Dear Mr Maund

Please see below for my final closing position and the key points I wish to make in opposition to the application for One Earth Solar Farm.

Figure 3-1: Groundwater Catchment and Groundwater Body Extent

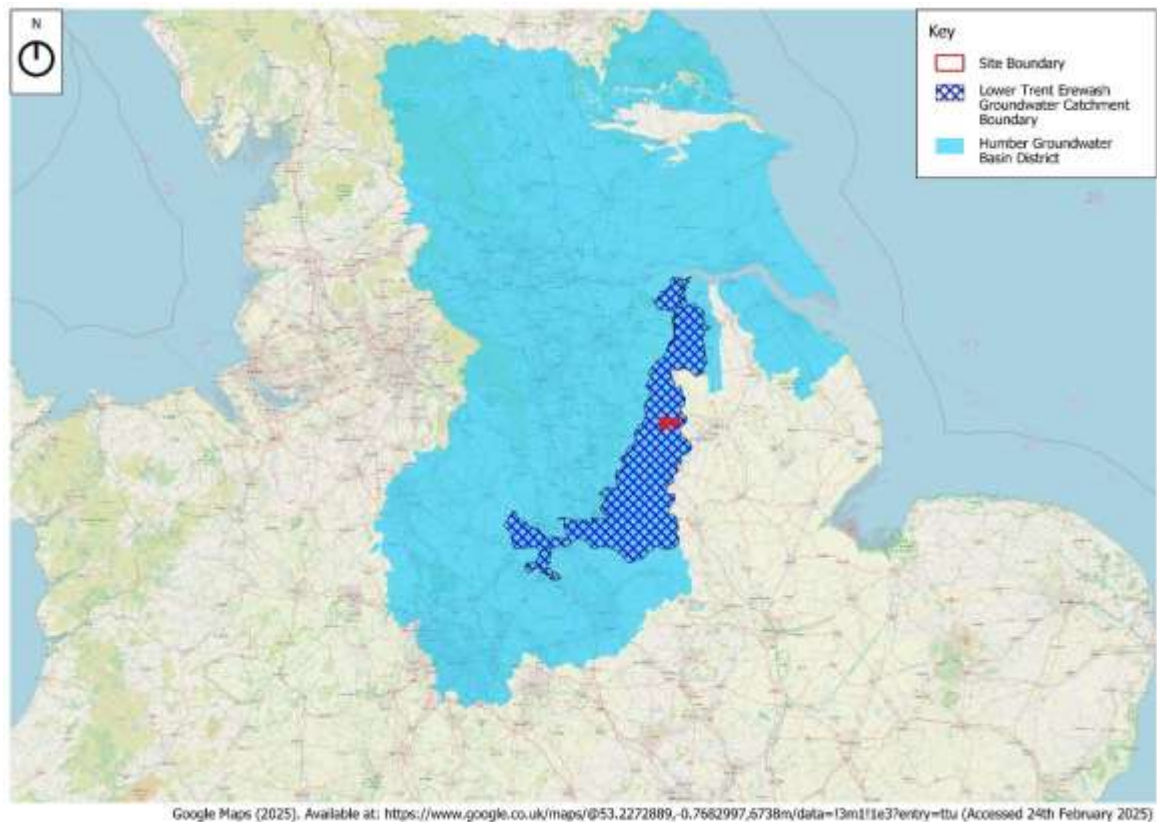
The site selected by the Applicant has a large proportion of it situated in a protected drinking water area.

Whilst the Applicant has provided document [REP4-018] 6.21.2 Appendix 7.4 Stage 1 Water Framework Directive Screening Assessment (Clean) (Rev 3) and states there will be no deterioration of a water body or failure to achieve good status or good potential, it is materially not possible to mitigate all the risks to ensure absolutely no deterioration of the water body in order to meet this statement. The fundamental purpose of risk mitigation is to reduce the likelihood of a risk occurring and/or minimising its impact or severity should it occur, rather than eliminating it entirely. Therefore, not amount of mitigation can eliminate the potential for contamination of the PDW area to become contaminated.

The Planning Inspectorate’s own NPS guidance explicitly requires “sufficient certainty” that no deterioration will occur and not a “risk-managed” approach or deferred mitigation. The only way the Applicant can fully mitigate the risk to the PDW Area is to remove all the infrastructure from this area meaning there would be no risk from fire/firewater contamination or pollution from the PV panels and PCS units. I would suggest the Applicant has not looked to do this as it would make the scheme unviable and is therefore using mitigation measures, they deem to be sufficient.

Because those legal tests aren’t met, the Secretary of State is required by law to refuse consent under paragraph 5.16.14 of NPS EN-1. The risk to the drinking-water environment is too high and cannot be justified when there are alternative sites available that could provide the same renewable energy, but without the risk to a PDW site.
